**Benedict Smeaton Grange Resource Recovery Facility (SSD 7424)  
Comment on the Environmental Impact Statement**

Mitchell Isaacs  
**Director, Planning Policy & Assessment Advice**  
26 August 2016

GROUND FLOOR PLAN  
SCALE 1:500

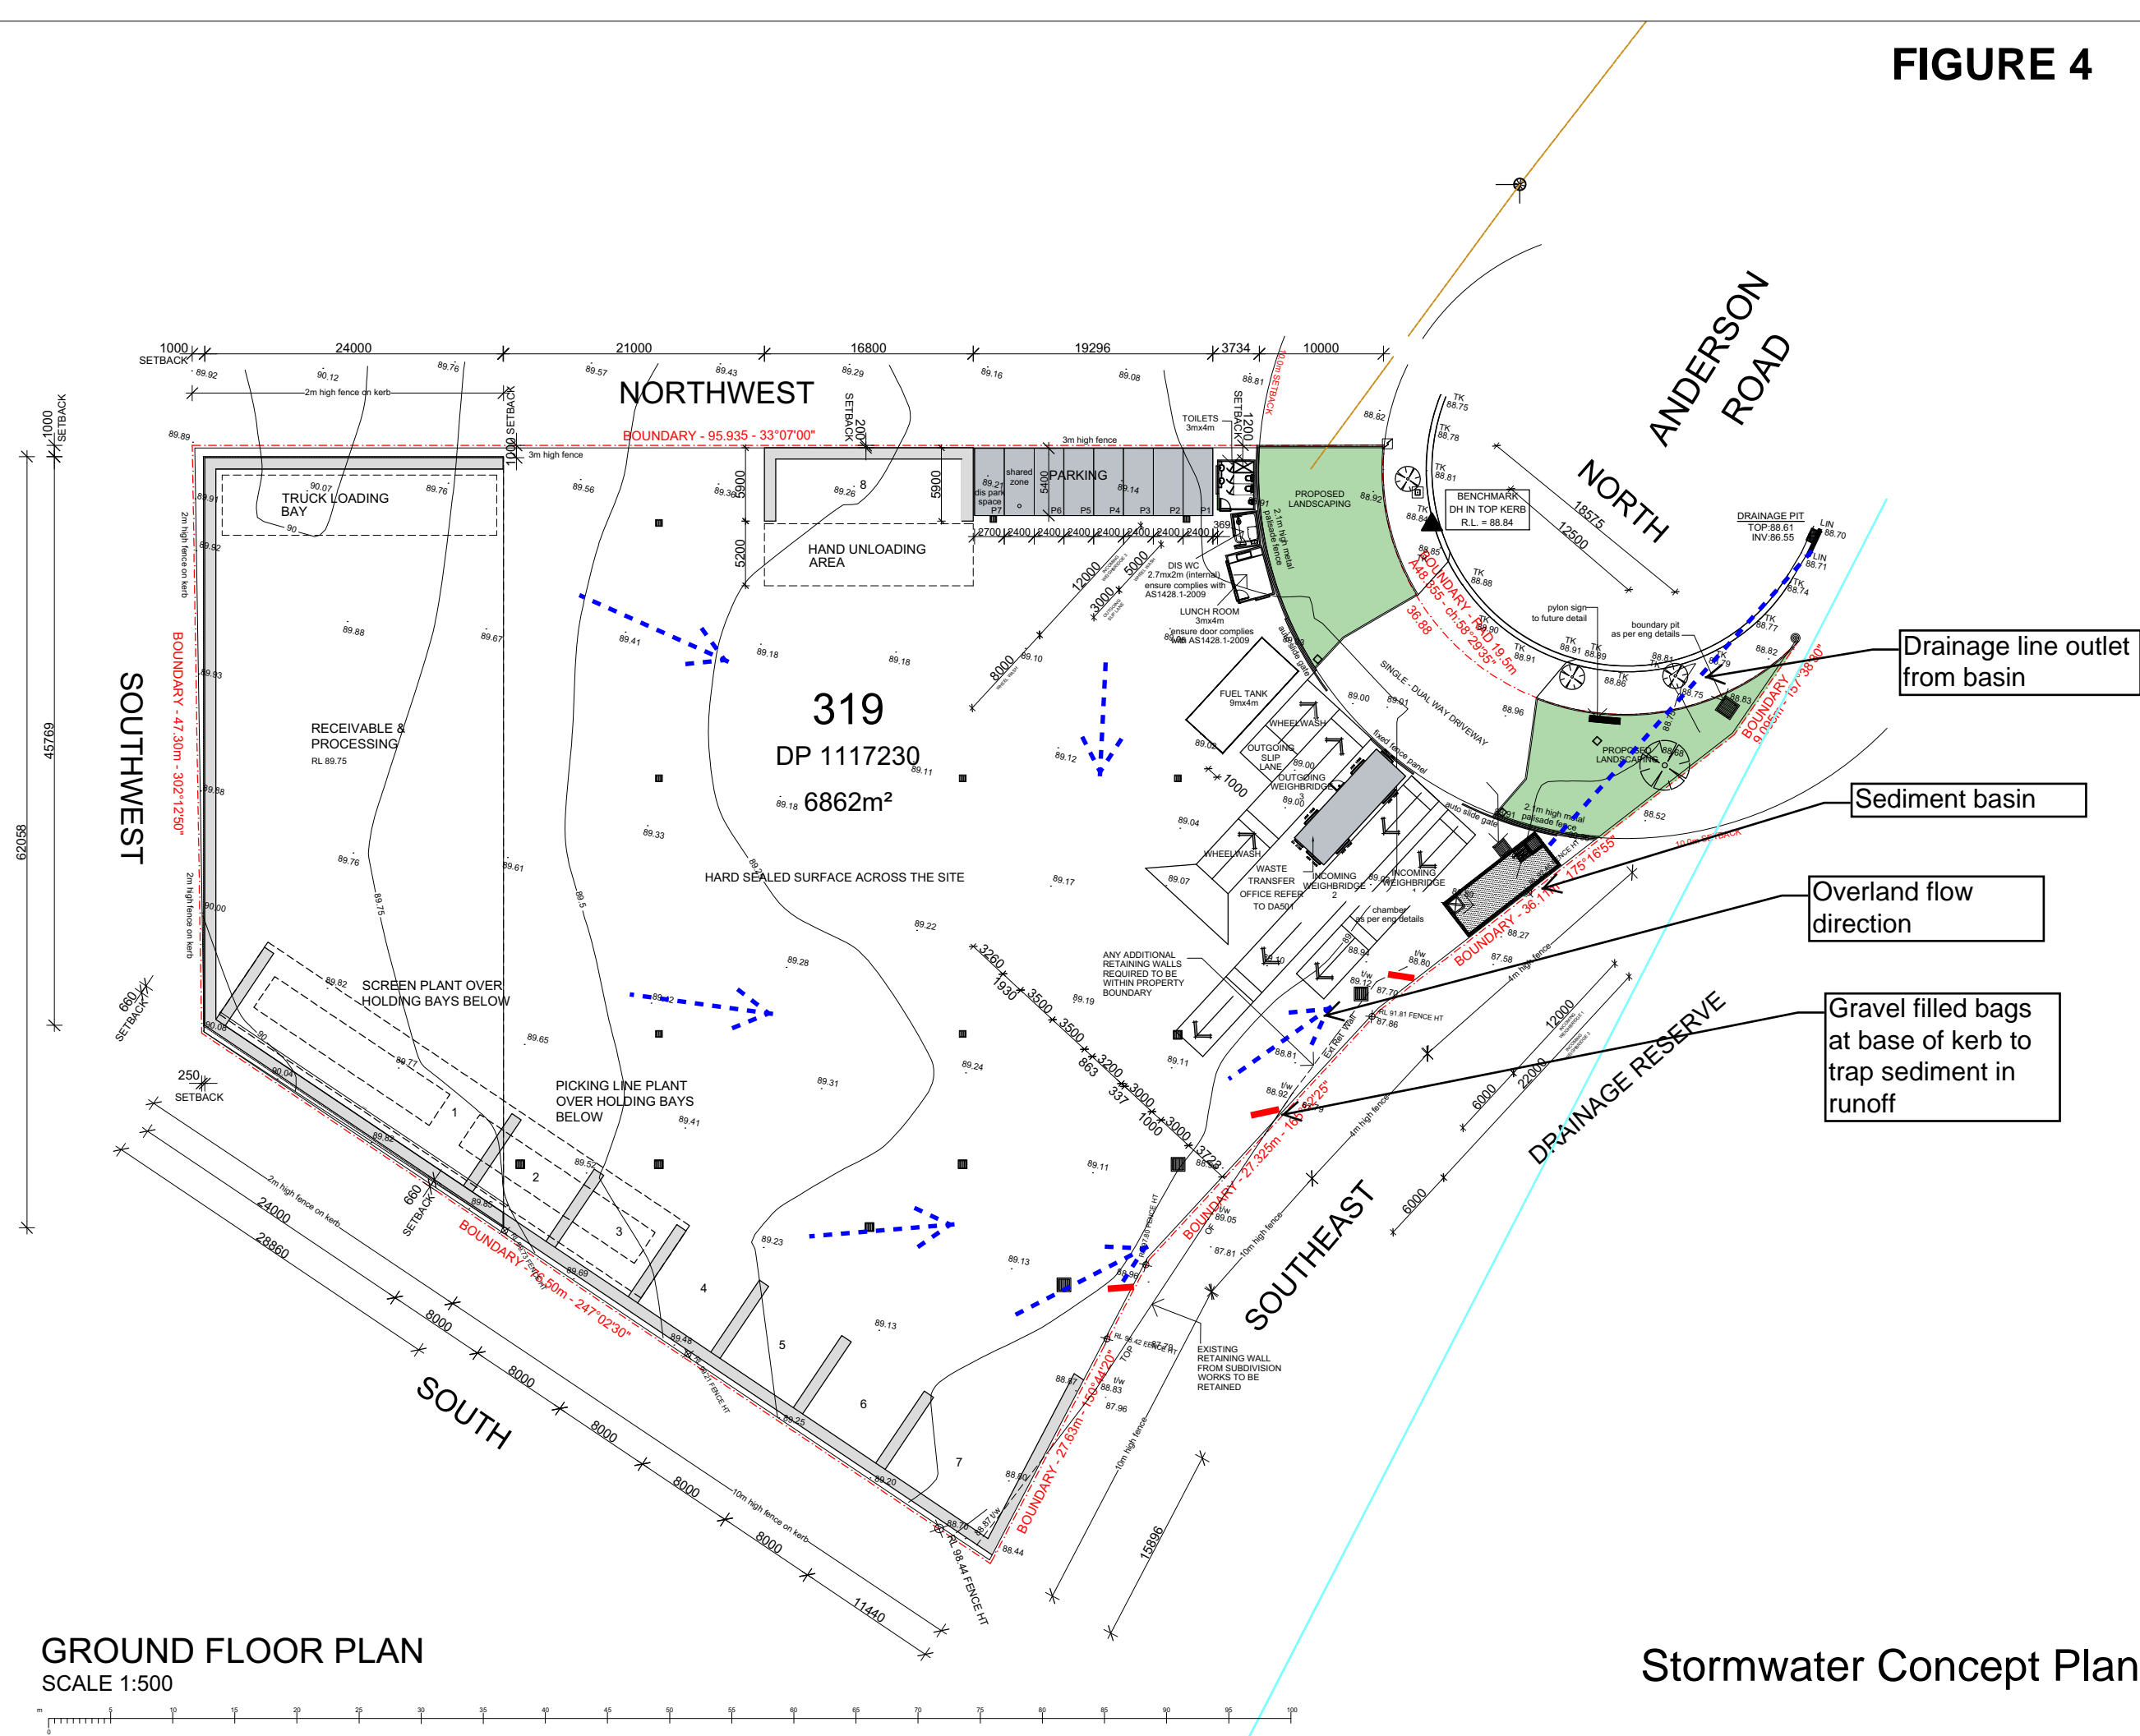
- The Ground Floor Plan (Appendix C of the EIS) shows a 4 m high and a 10 m high fence is located beyond the site boundary within the riparian corridor of Kenny Creek. The proponent should clarify whether the fence is an existing structure, or if the fence is to form part of the SSD project. If so, details are required as to why the fence is located within the riparian corridor and not along the site boundary.
